**Transport
for NSW**

**Wahroonga Adventist School, Wahroonga (SSD 5535)
NOTICE OF EXHIBITION**

Attachment 1 – TfNSW Response to SSD 5535: Wahroonga Adventist School

fox valley road intersection  
 job number 1318.10  
 dwg. no. / issue & amendment  
 DA02A/1

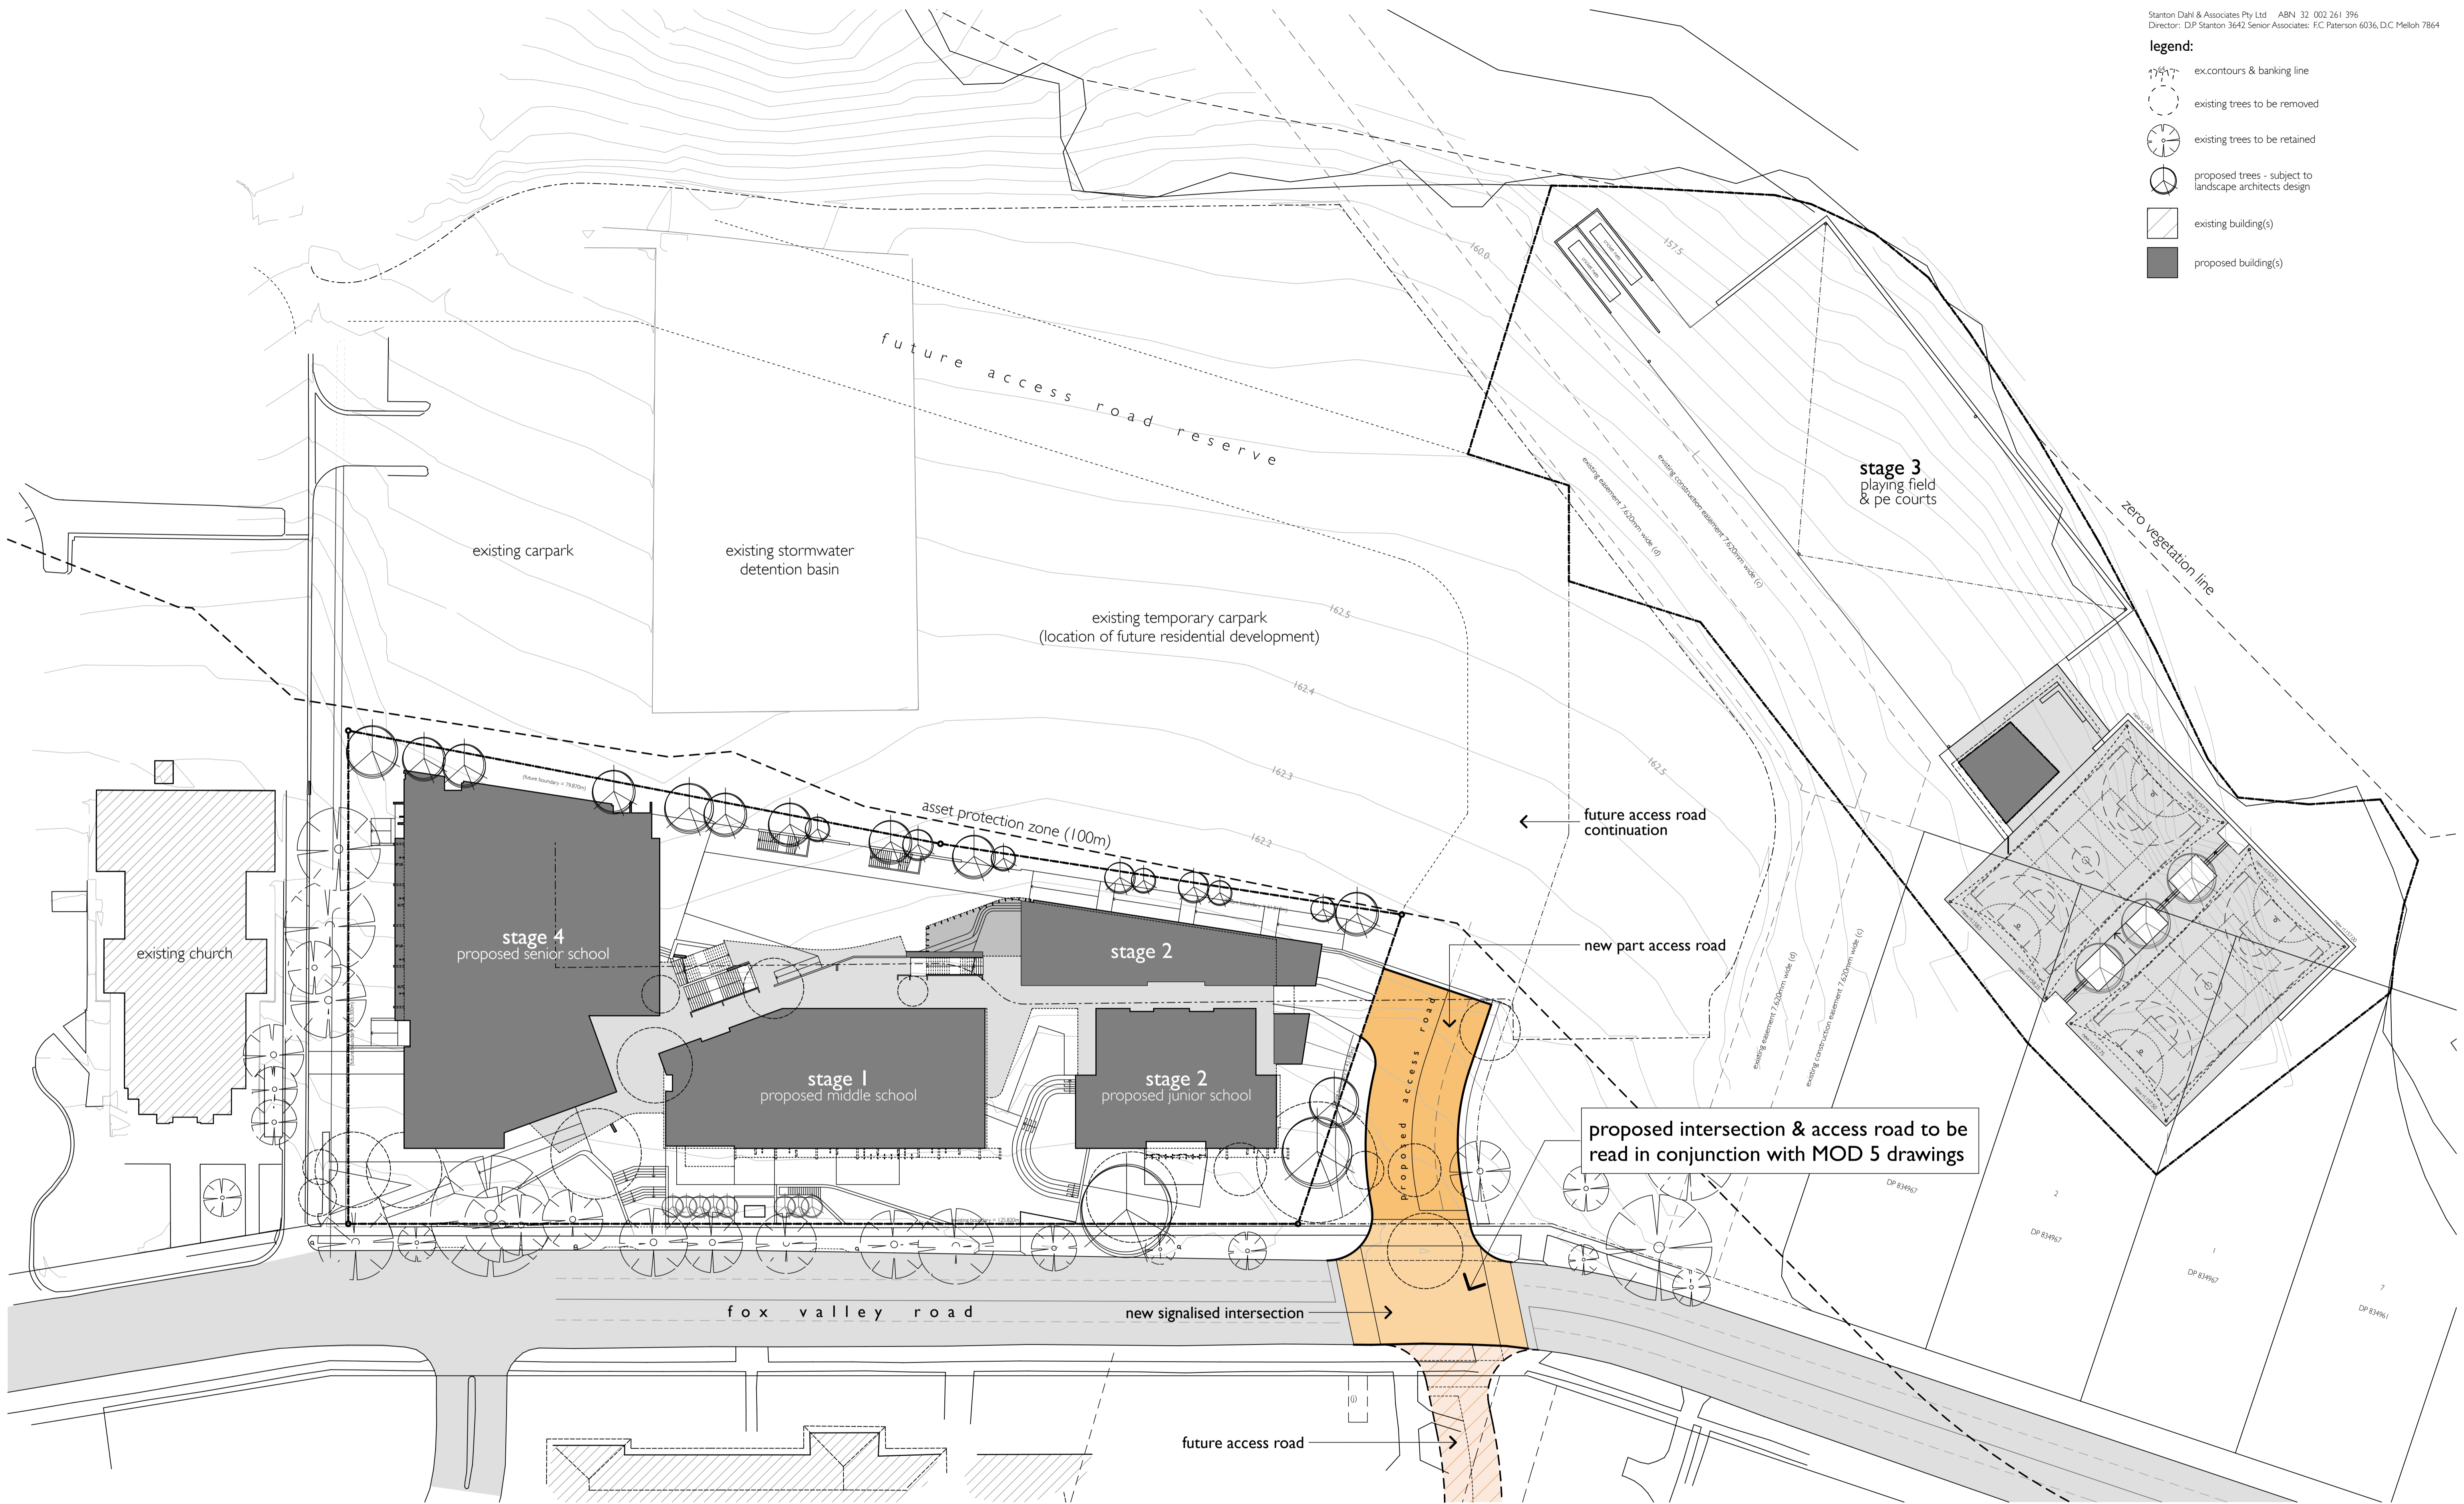
1. An approved location-specific sustainable travel plan, and
2. Off-road pedestrian and cycle facilities be incorporated into the new access road that connects Fox Valley Road to the school and adjacent residential dwellings.

Note: A 3.5m visually separated pedestrian and cycle path is preferred to a shared path facility.

Consideration should be given to including bicycle crossing lanterns at the proposed signals and ensure that all paths comply with DDA and CPTED (Crime Prevention Through Environmental Design) principles.
